From: Laura Gibbons
Sent: 20 July 2018 16:10
To: Planning.Responses
Subject: RE: Planning Consultation on EP/96/18/DOC

Engineers Comments Regarding Condition 9 and 10

APPLICATION EP/96/18/DOC
NO:

Registered: 26-JUN-18
Site Address: Tudor Lodge 125A Sea Road East Preston BN16 1NX

L2340-C-52-750 – Drainage for Planning

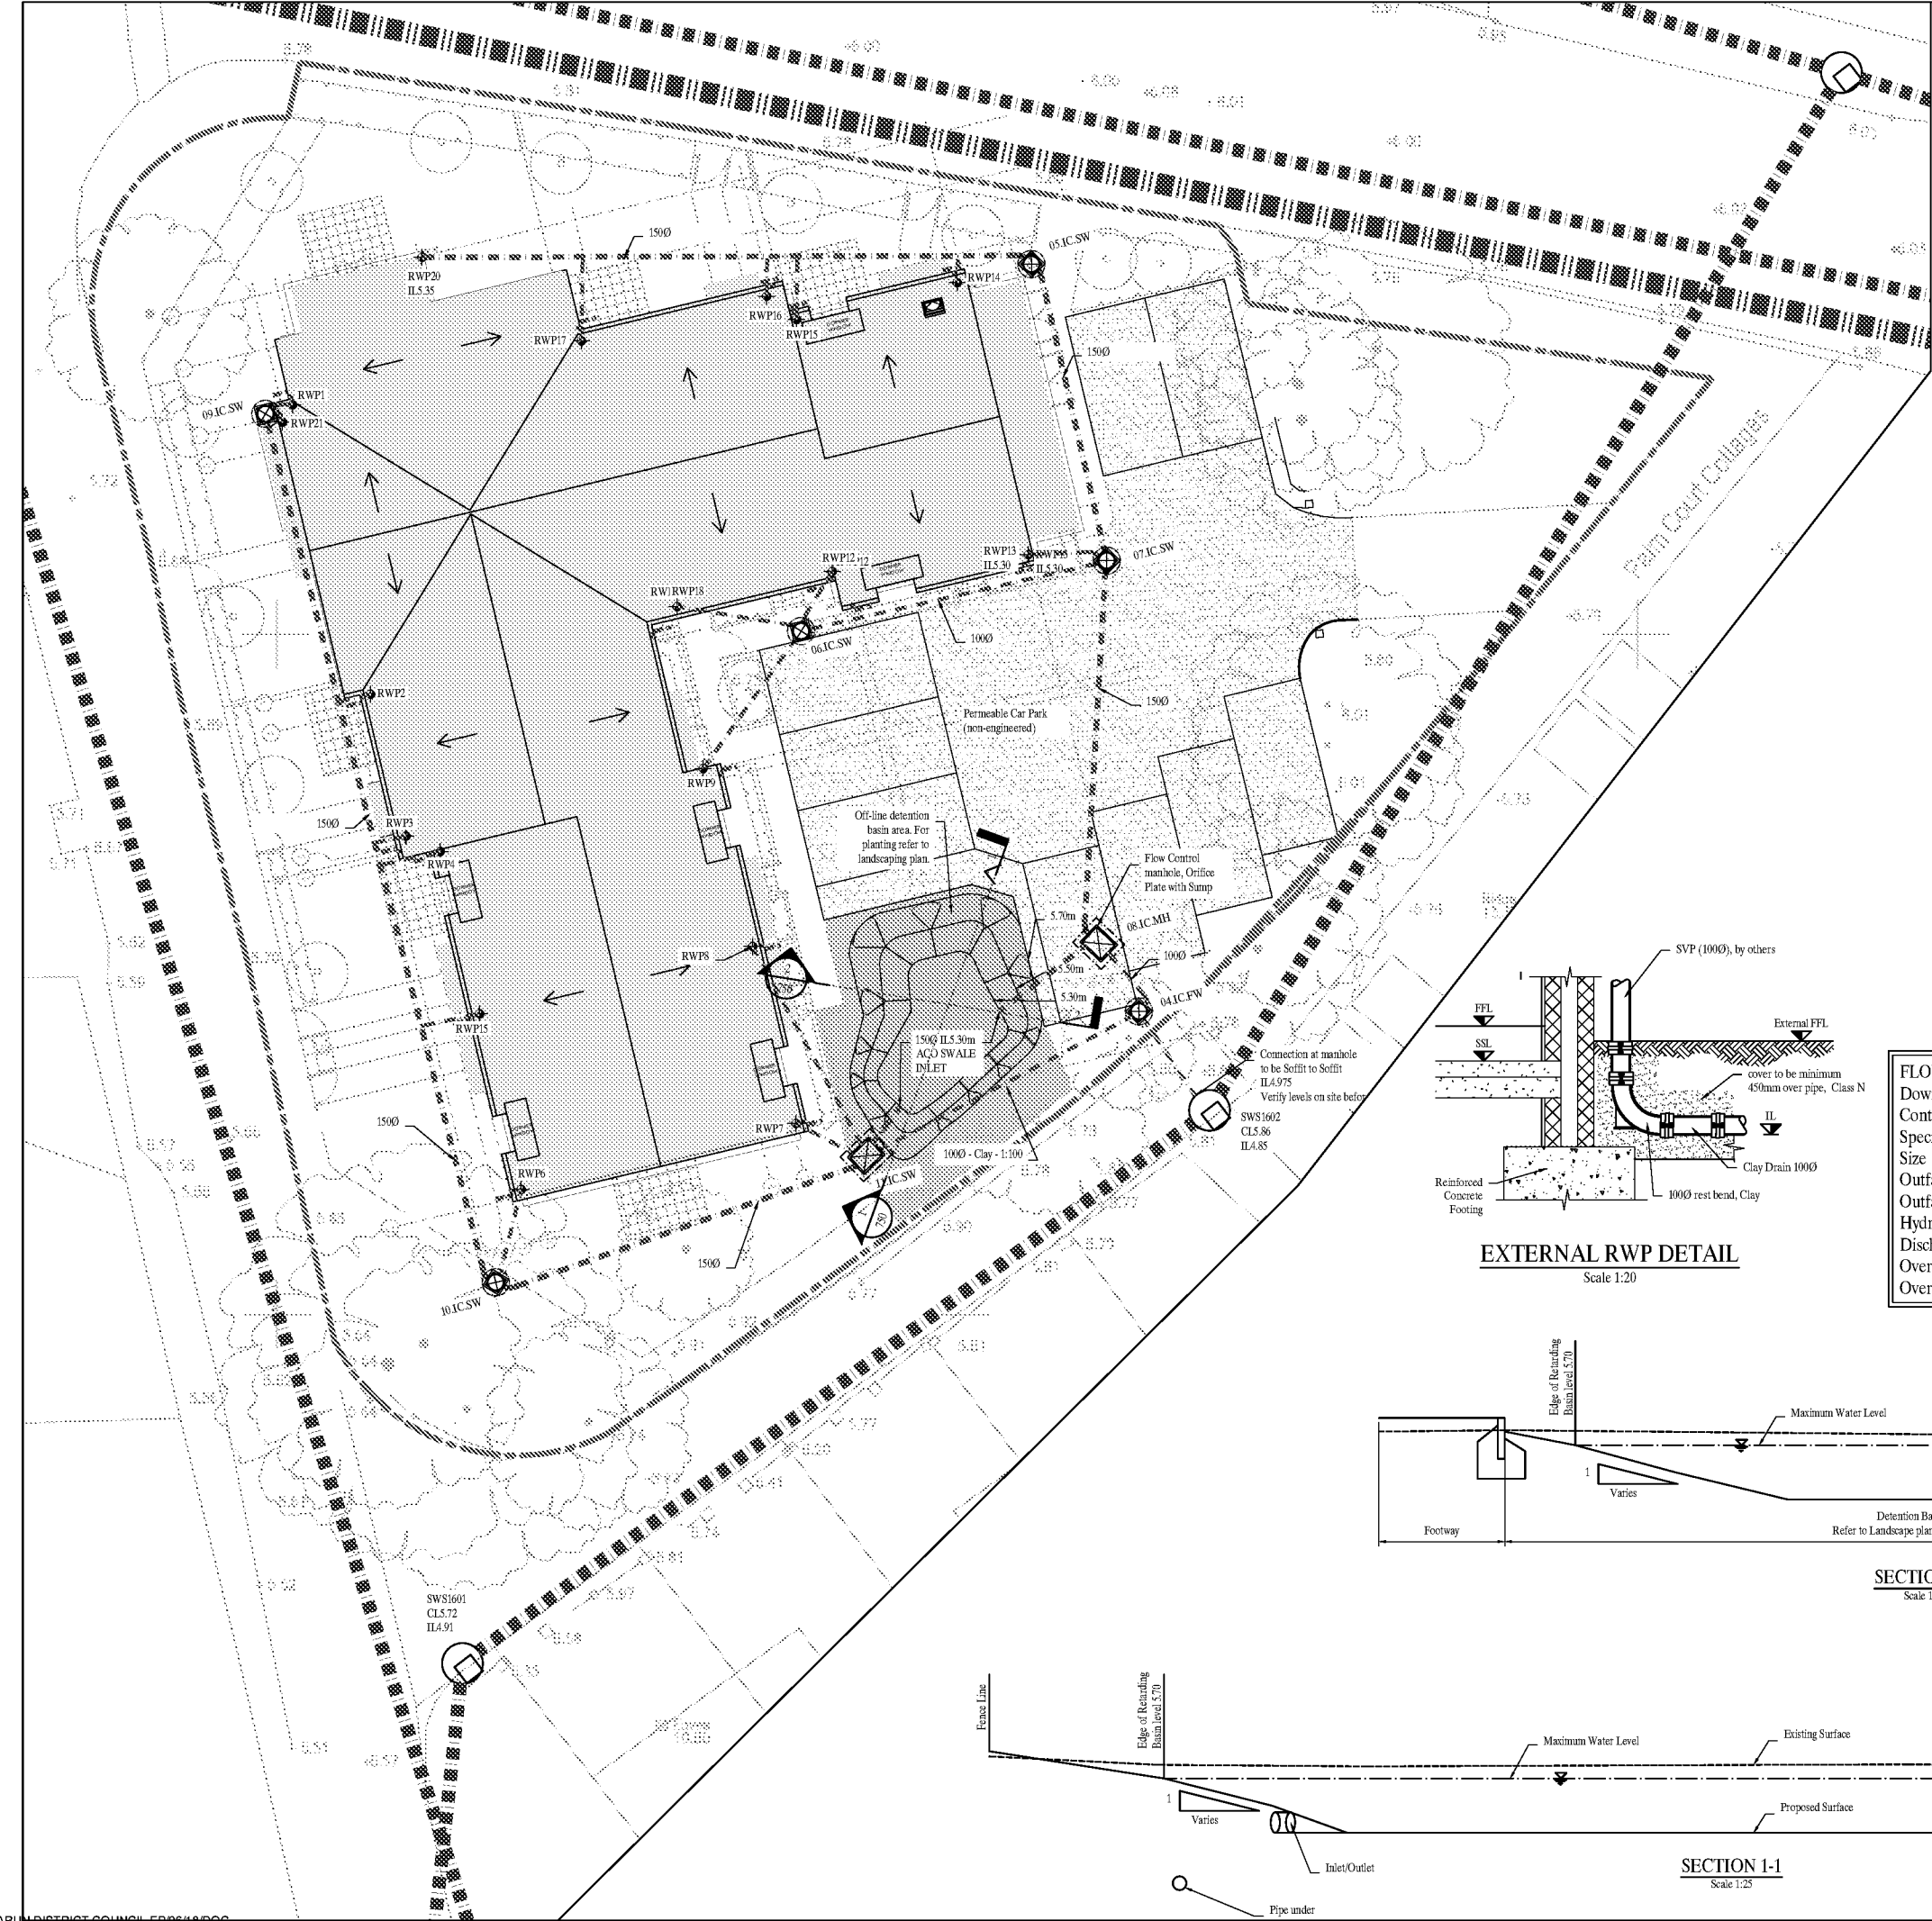
The applicant has not provided winter infiltration test results to show that infiltration is not viable. Please provide these.

Groundwater levels of 1.6m are not sufficient justification to rule out infiltration.
